From: Holly Erdman
Sent: Thursday, August 01, 2019 4:24 PM
To: Chelsea Benner
Cc: Jesse Cox
Subject: RE: BL-19-00013 Bugni

From: Chelsea Benner
Sent: Monday, July 22, 2019 11:00 AM
To: Holly Erdman; Jesse Cox; Pat Nicholson; Karen Hodges; Taylor Gustafson; Toni Berkshire
Subject: BL-19-00013 Bugni

Please review the following Boundary Line Adjustment application submitted by Theresa Bugni (BL-19-00013). Any comments need to be submitted by 5pm on August 5th. Please let me know if you have any questions.

**PART OF SECTION 3,
TOWNSHIP 19 NORTH, RANGE 16 EAST, W.M.
PROPOSED**

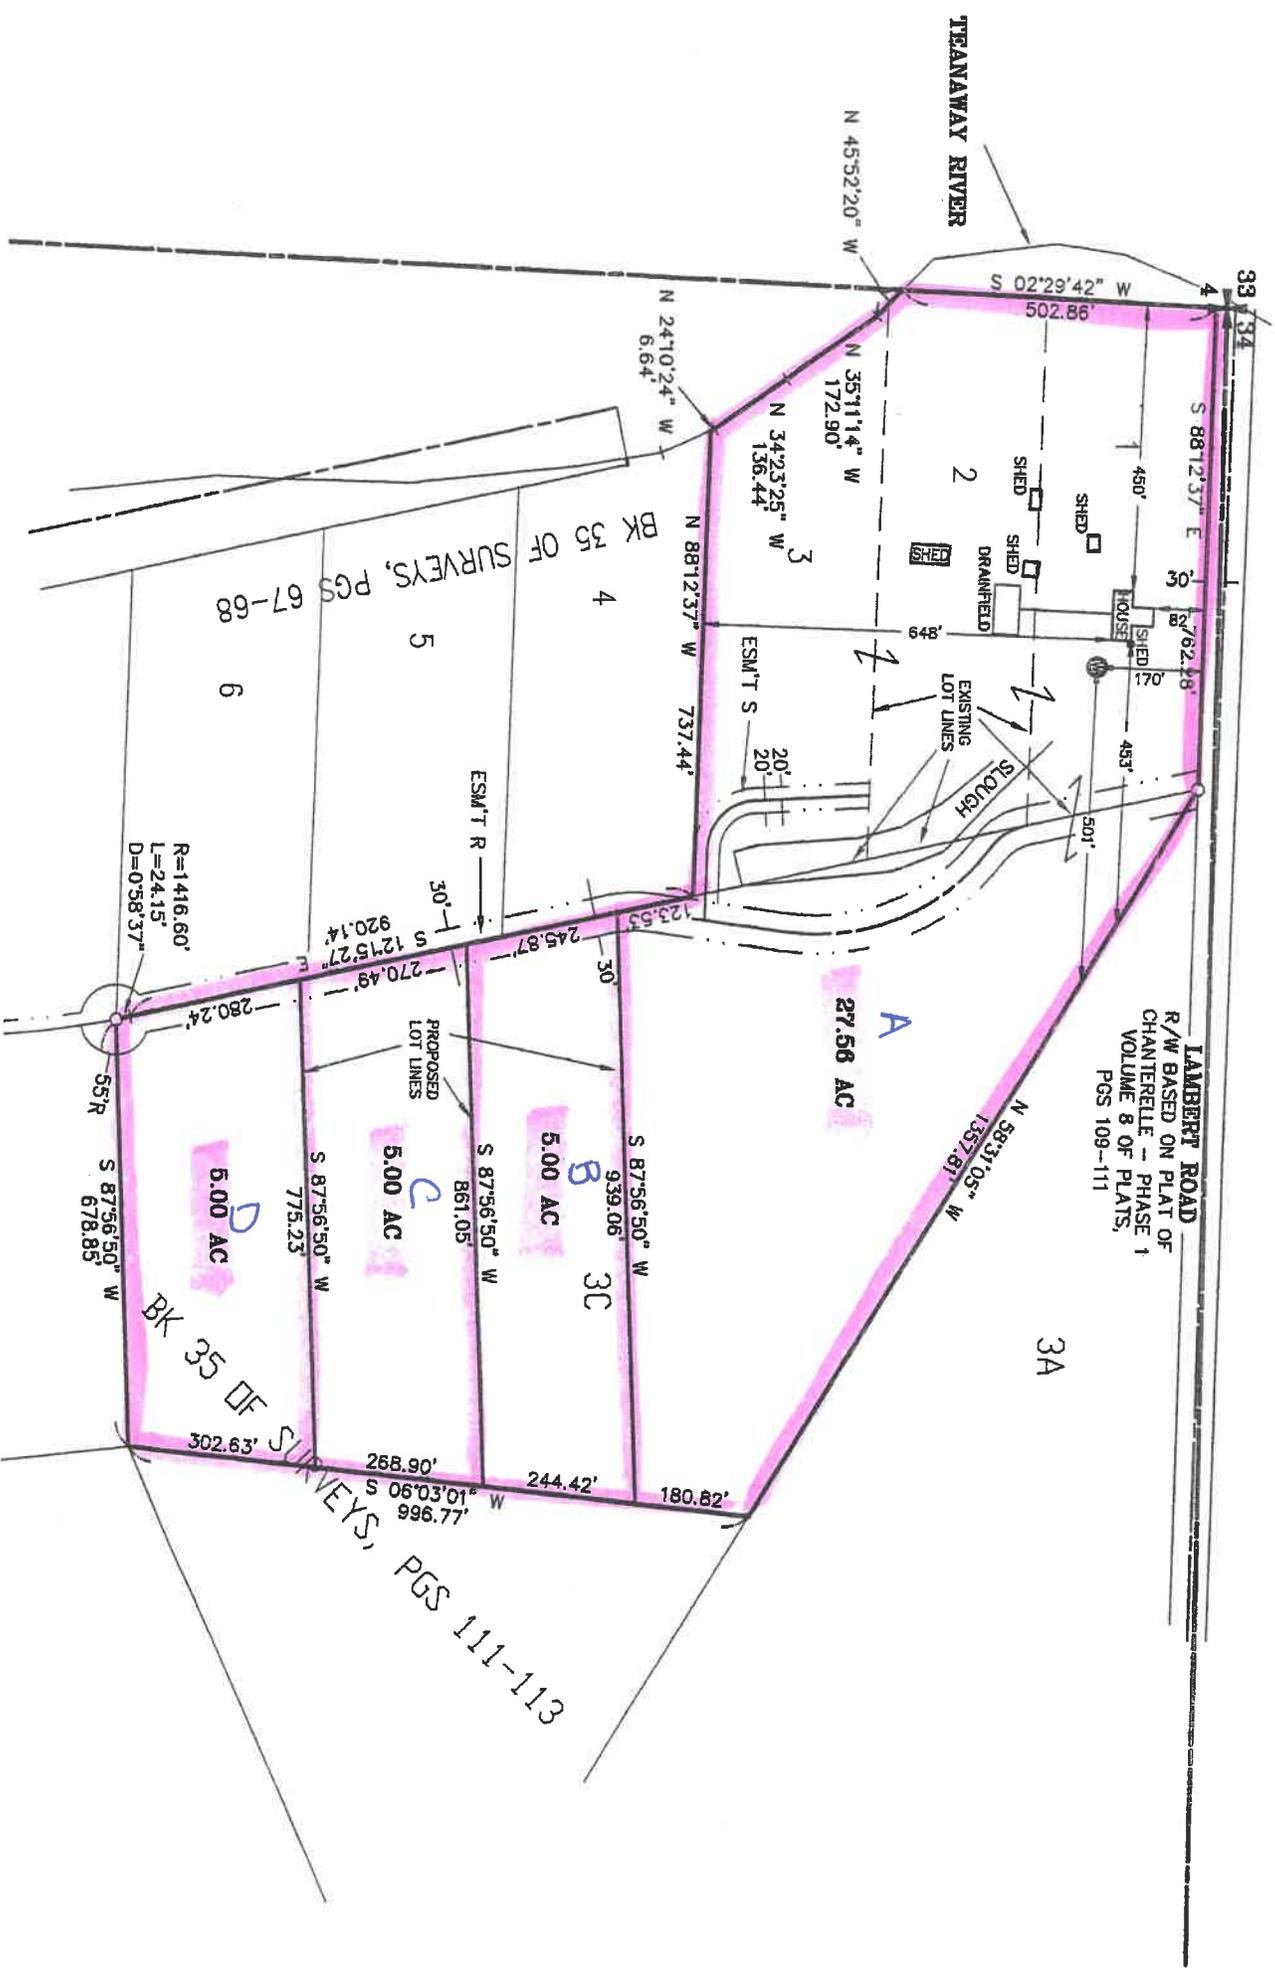
After review of this BL it appears that the proposed lot lines meet all required setbacks from the existing well and drainfield. Public health has no further concern.
